**SYDNEY OLYMPIC PARK AUTHORITY  
DESIGN REVIEW PANEL  
ADVICE SHEET**

**Re: SITE 9 HOSPITAL DEVELOPMENT, SYDNEY OLYMPIC PARK**

<b>Project</b>	3.2 – Site 9
<b>Presentation / Review Date</b>	19 <sup>th</sup> July 2007
<b>Panel Present</b>	Peter Mould Philip Thalís Darlene van der Breggen (SOPA)
<b>COI Declaration</b>	nil
<b>Also Present</b>	Brian Newman (SOPA) Craig Bagley (SOPA) Steve Jensen (SOPA)
<b>Presenters</b>	Noel Samyia (PTW Architects)
<b>Documents made available</b>	PP presentation and A1 drawings
<b>Inherited decisions</b>	Existing DA for commercial office building
<b>Previous relevant SOPA Advice</b>	DRP Advice sheet – 21st June 2007.
<b>General Observations/ Overall Comment</b>	Many of the previous concerns had been addressed through substantial changes to the internal planning and external elevation treatments
<b>Positives</b>	The Panel supported: <ul style="list-style-type: none"> <li>• Structural changes that provide a covered colonnade along the Olympic Blvd frontage.</li> <li>• Plan amendments that reduce the building depth on the Sarah Durack frontage.</li> <li>• Incorporation of naturally ventilated break out spaces.</li> <li>• Façade detailing more closely re

DA 007 D

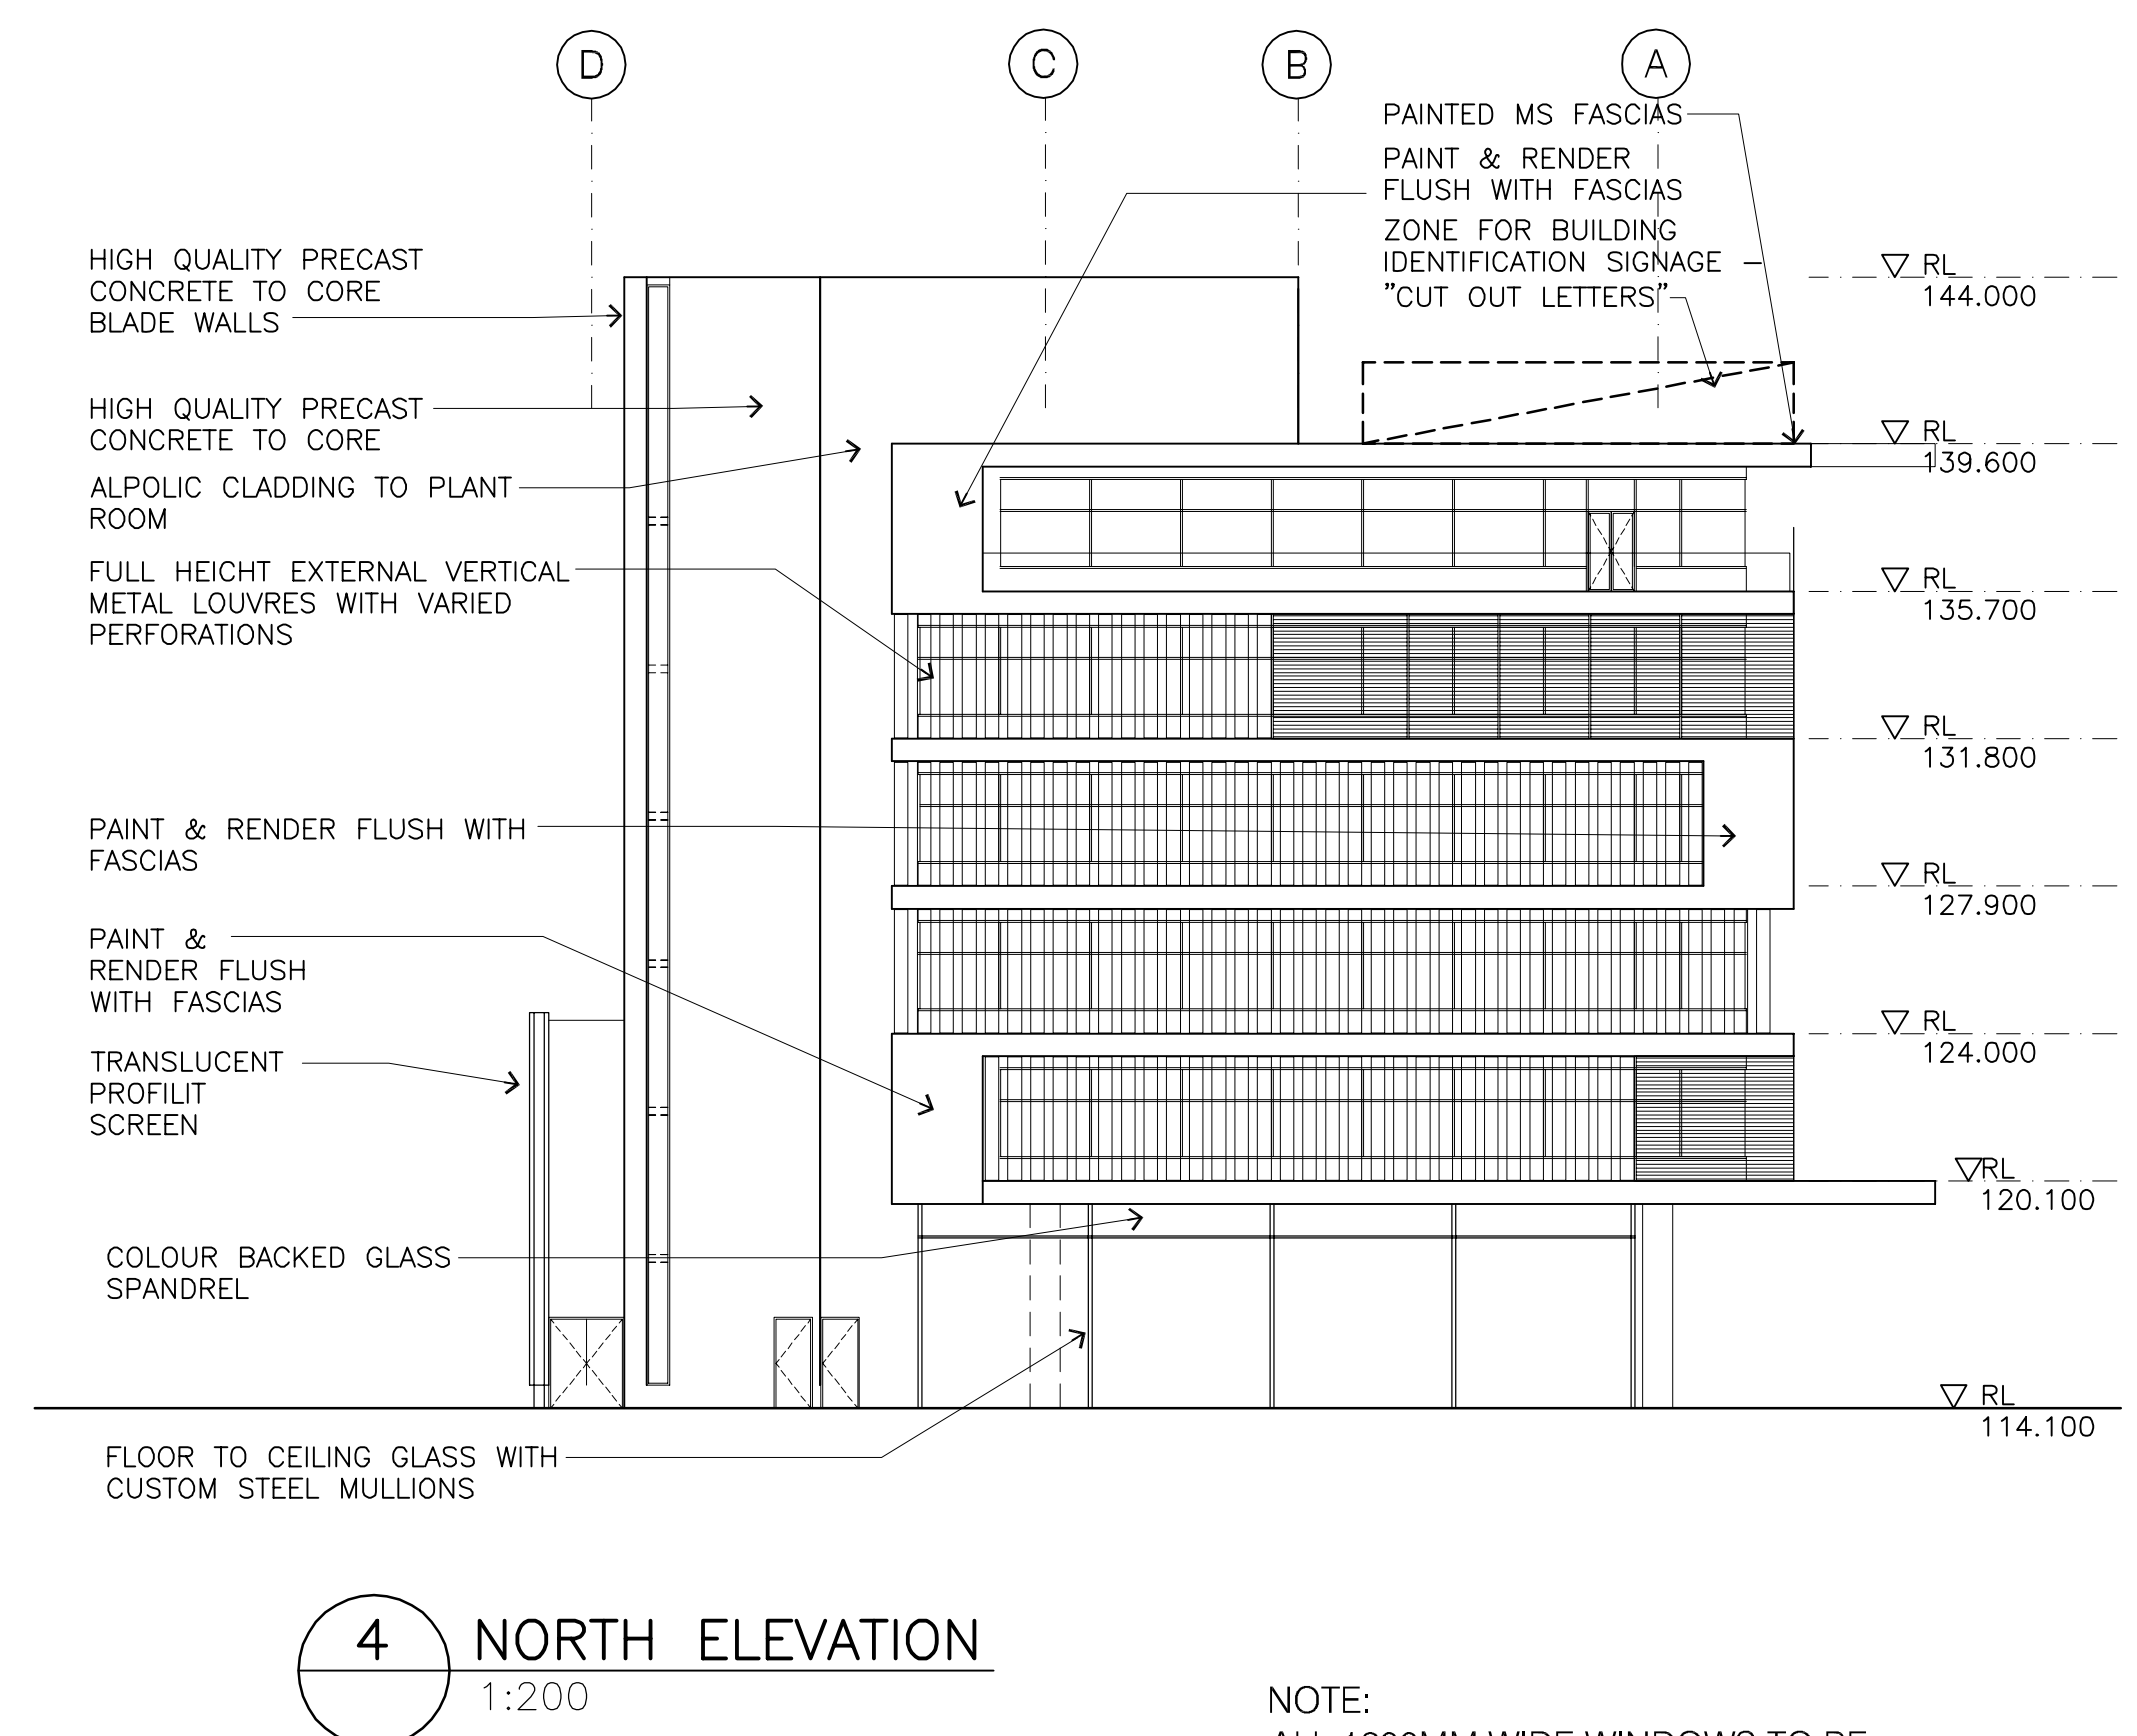
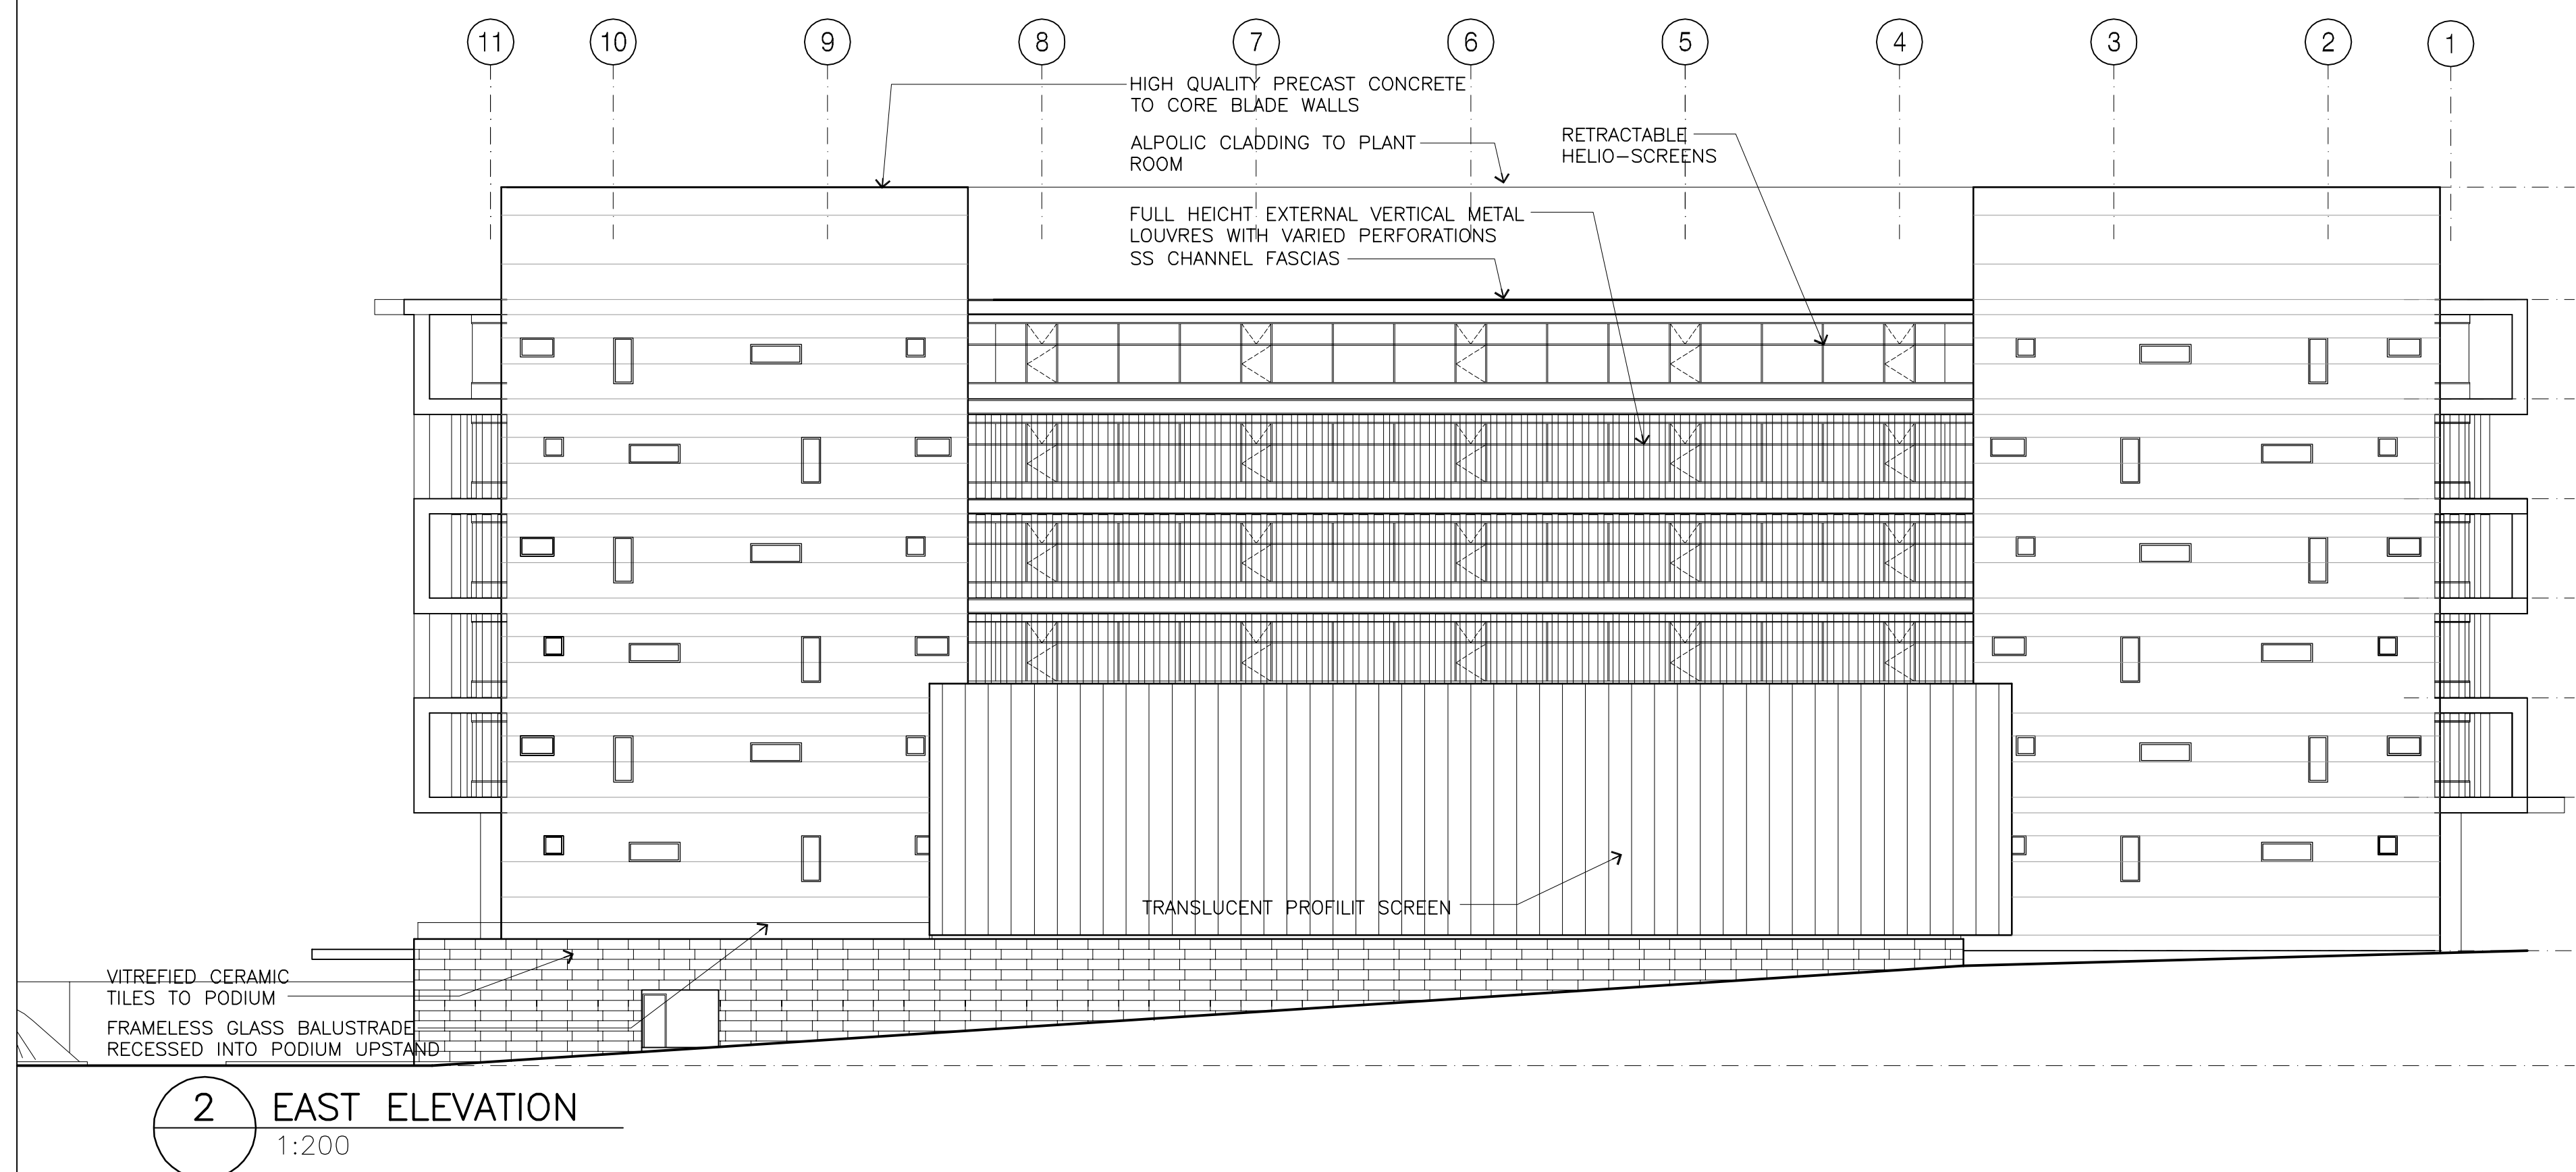
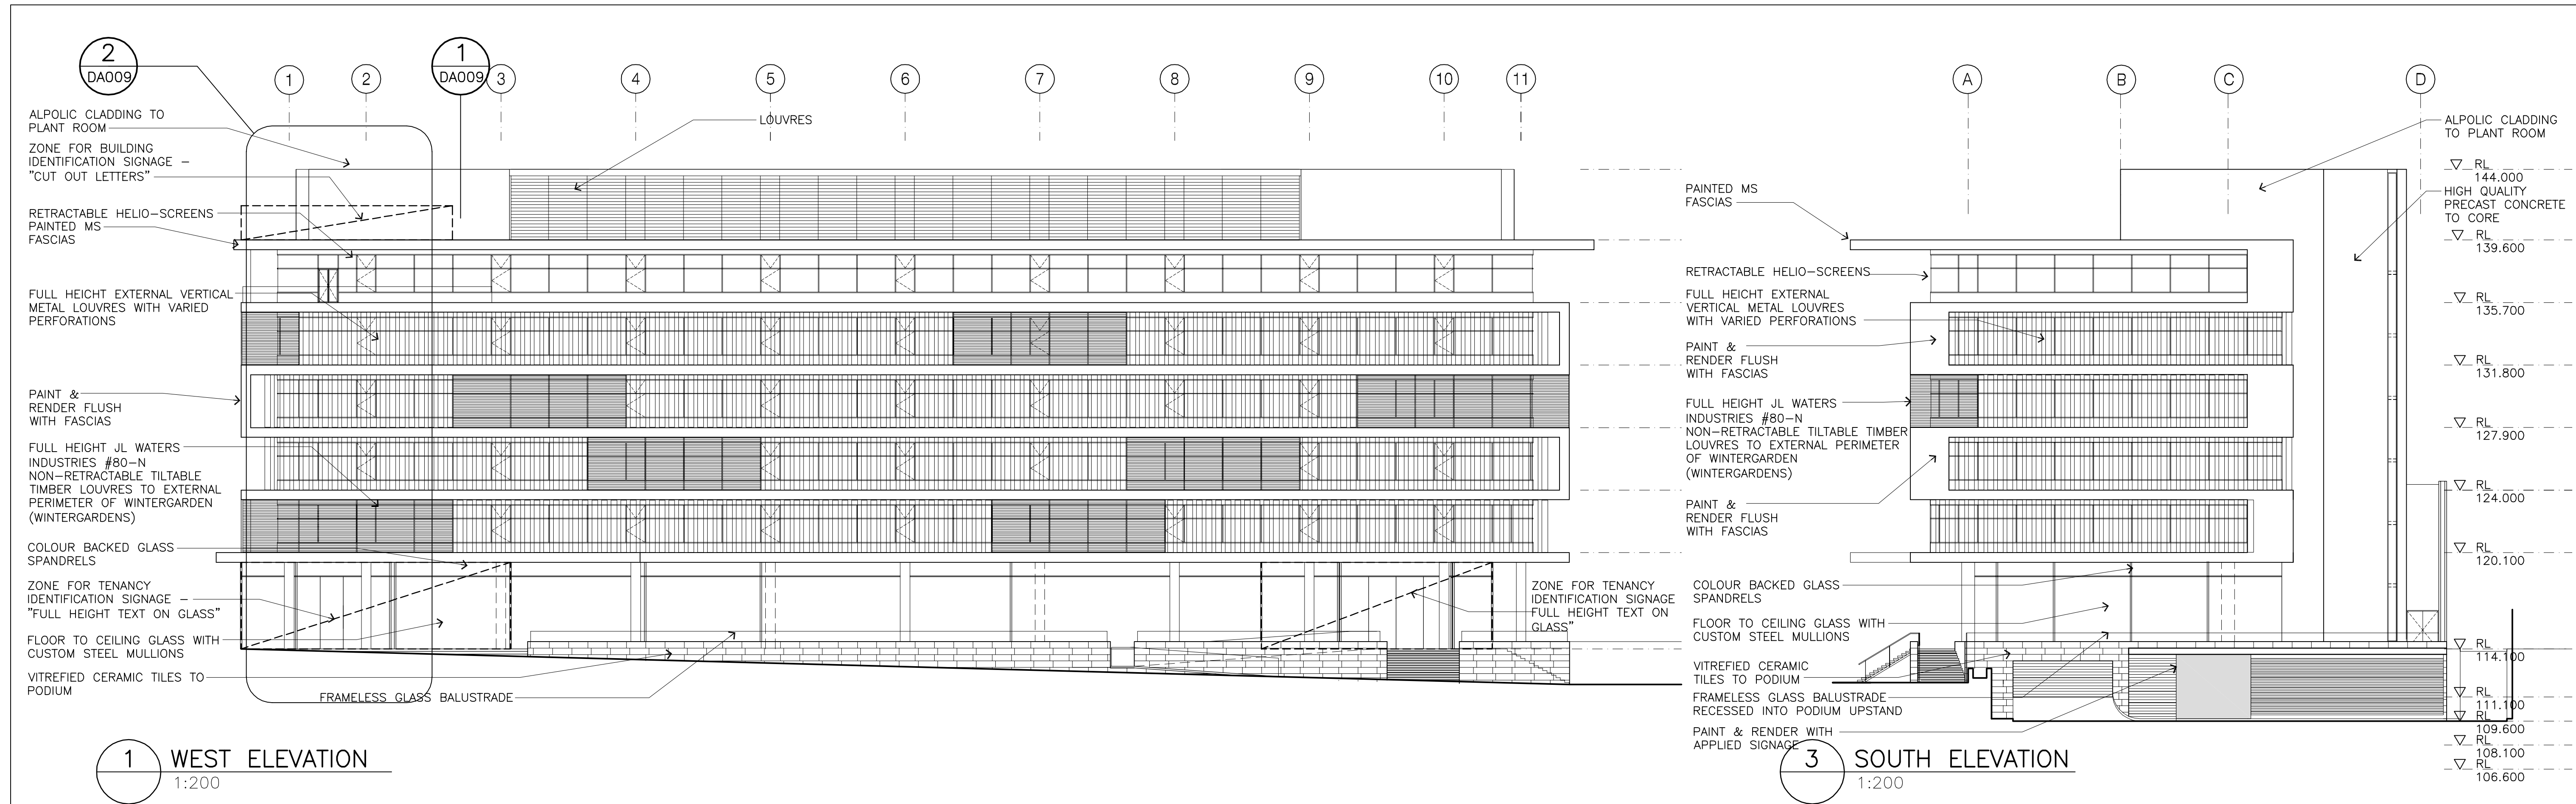
1. Elevation treatments, especially to the upper levels are overly complex and have not captured the clarity and simplicity of the previous building design. – consider repeating the louvred screens for the upper levels.
2. The colonnade should be on grade with adjacent natural ground levels – review basement design to allow slab set-down for colonnade.
